BE/106/17/DOC

**Proposal: Application for approval of details reserved by condition imposed under BE/45/16/PL relating to conditions 3-schedule & samples of materials & finishes, 4-landscaping scheme, 5-details of screen walls and/or fences, 6- vehicle access construction, 7-Construction Management Plan, 8-surface water drainage, 9-details of foul sewerage disposal, 10-maintenance of SUDs system, 11-access & management of any watercourse, 15-details of waste & recycling enclosures & 18-covered & secure cycle parking spaces.**

**Site: 27 North Bersted Street, Bersted, PO22 9AA.**  
**BE/106/17/DOC**

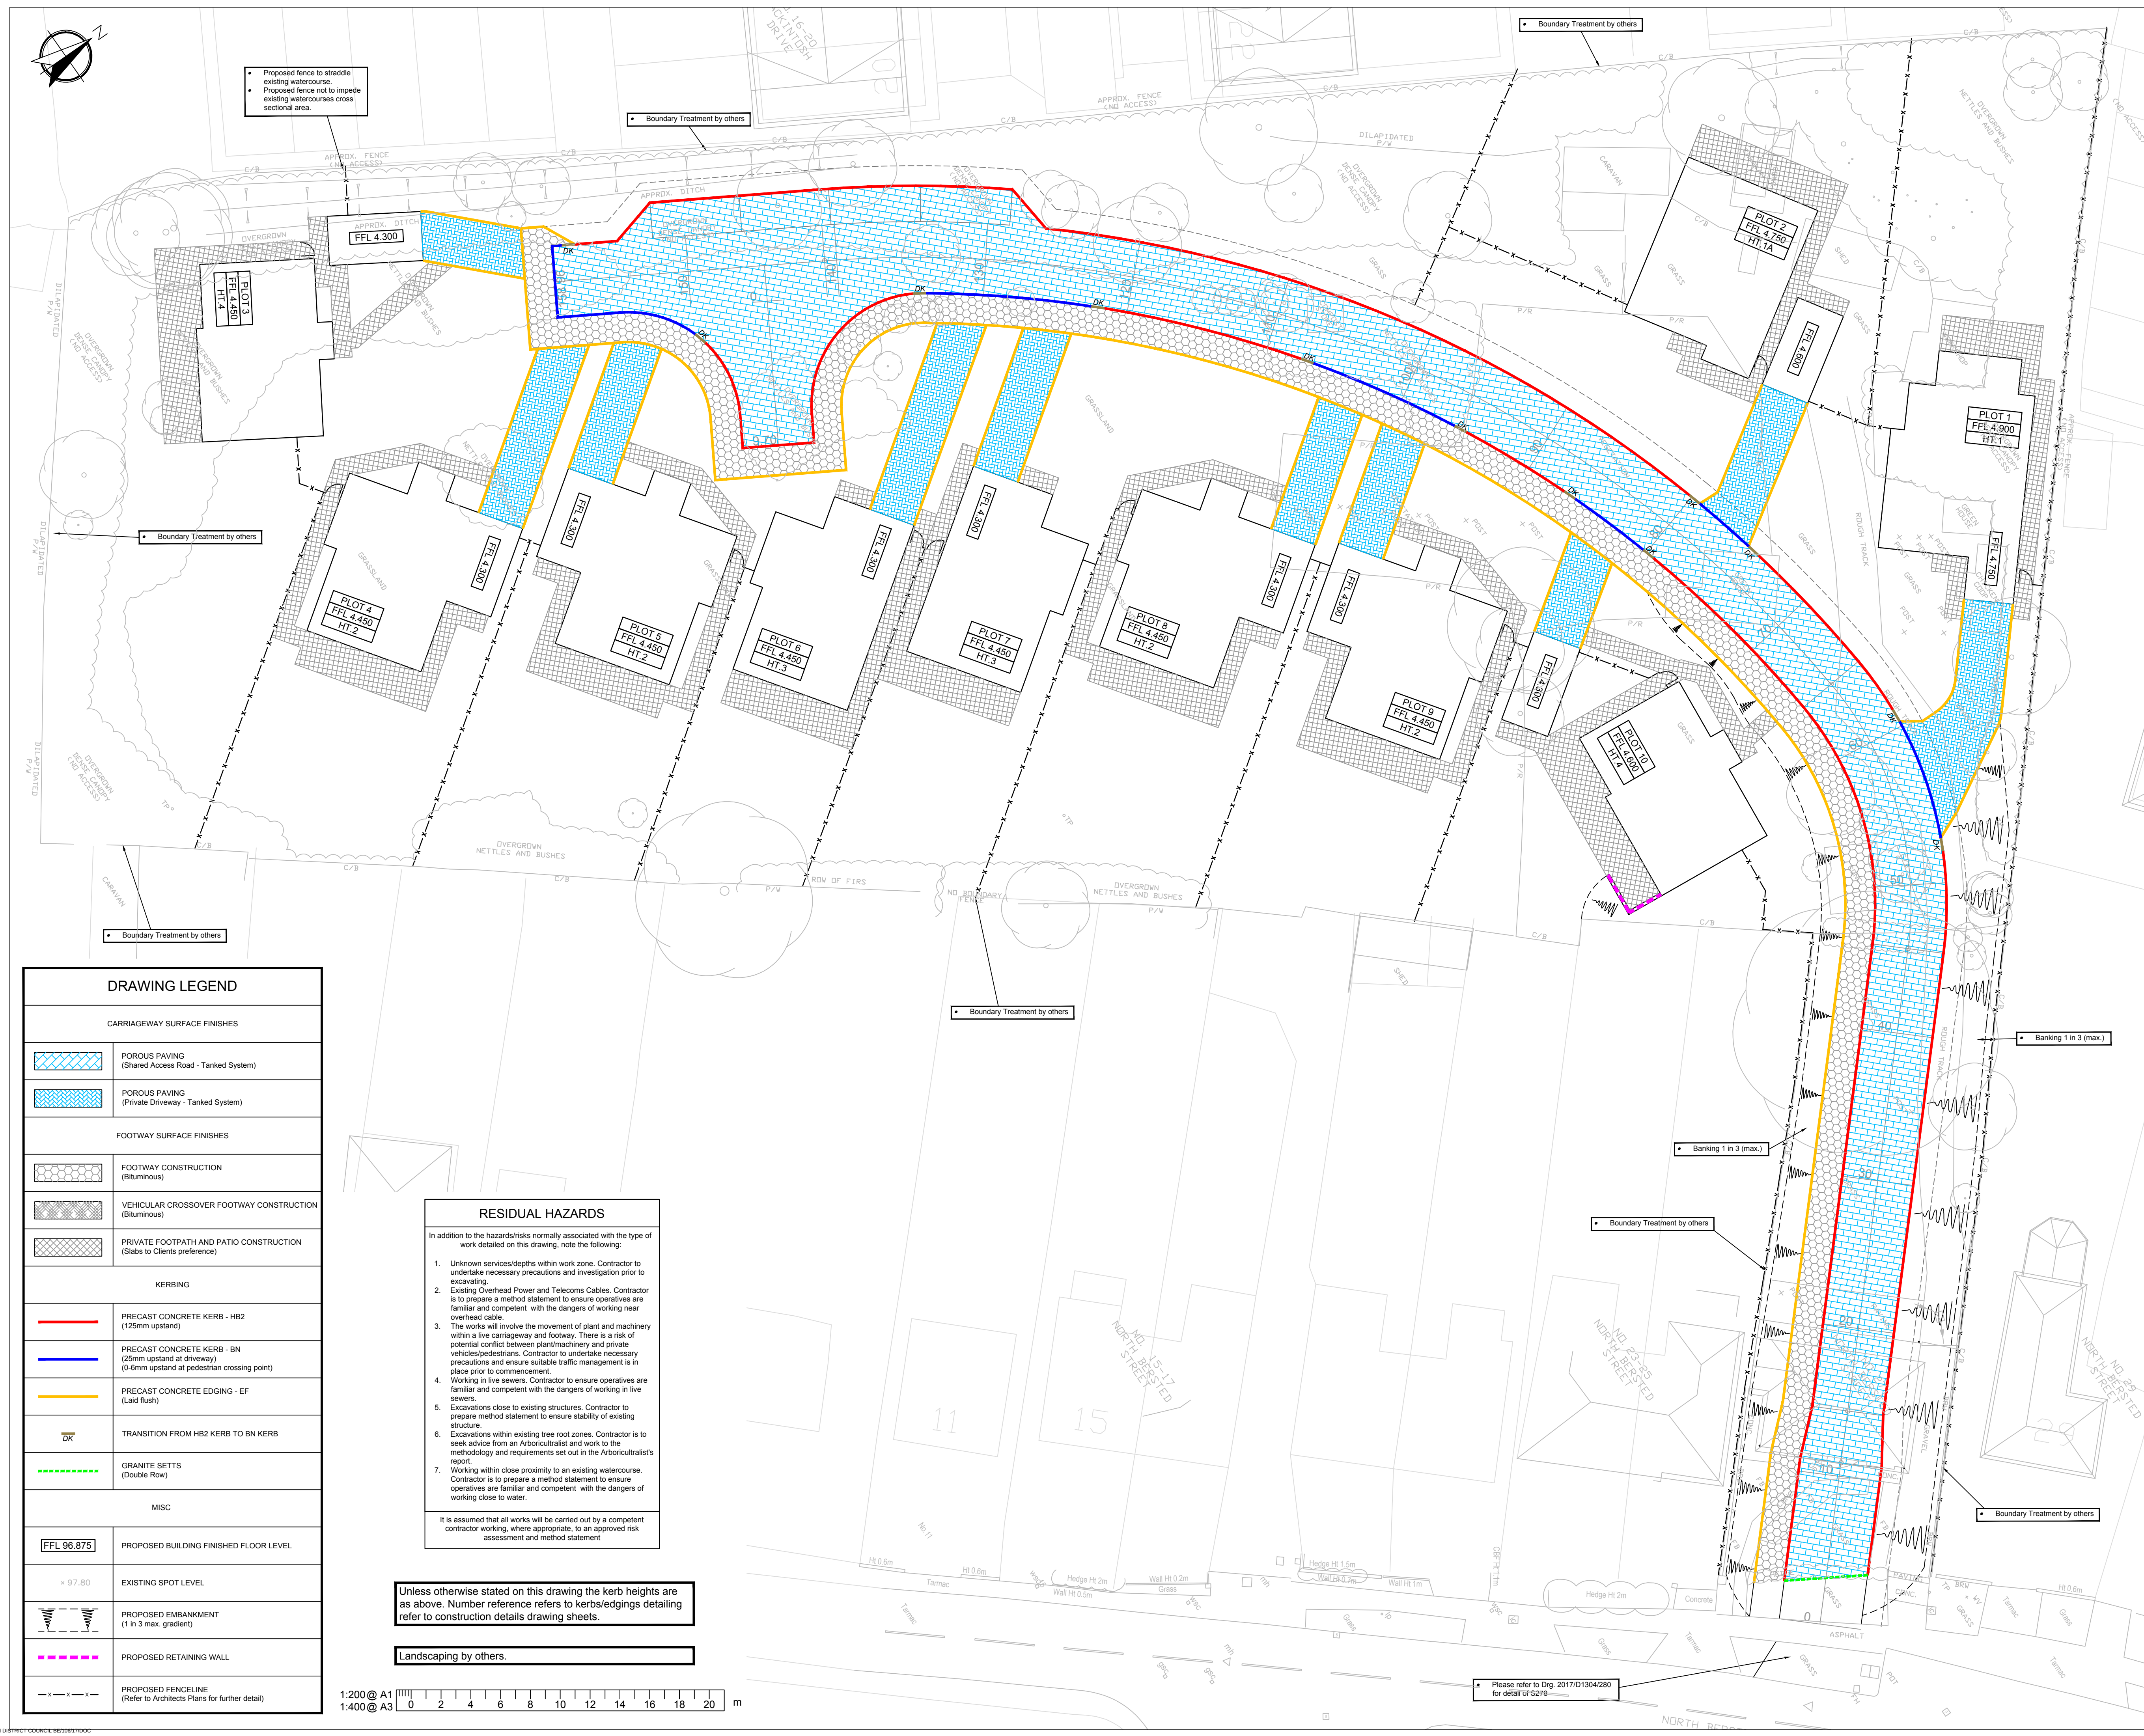
Southern Water would not recommend discharge of condition 9 relating to foul drainage. The proposed foul drainage is not designed to adoptable standards and Southern Water requirements. The construction of tanked permeable paving over or within proximity of tanked permeable paving will not be acceptable to Southern Water.

The consent of the Highway Authority will be required for the proposed discharge of surface water to the Highway drain.
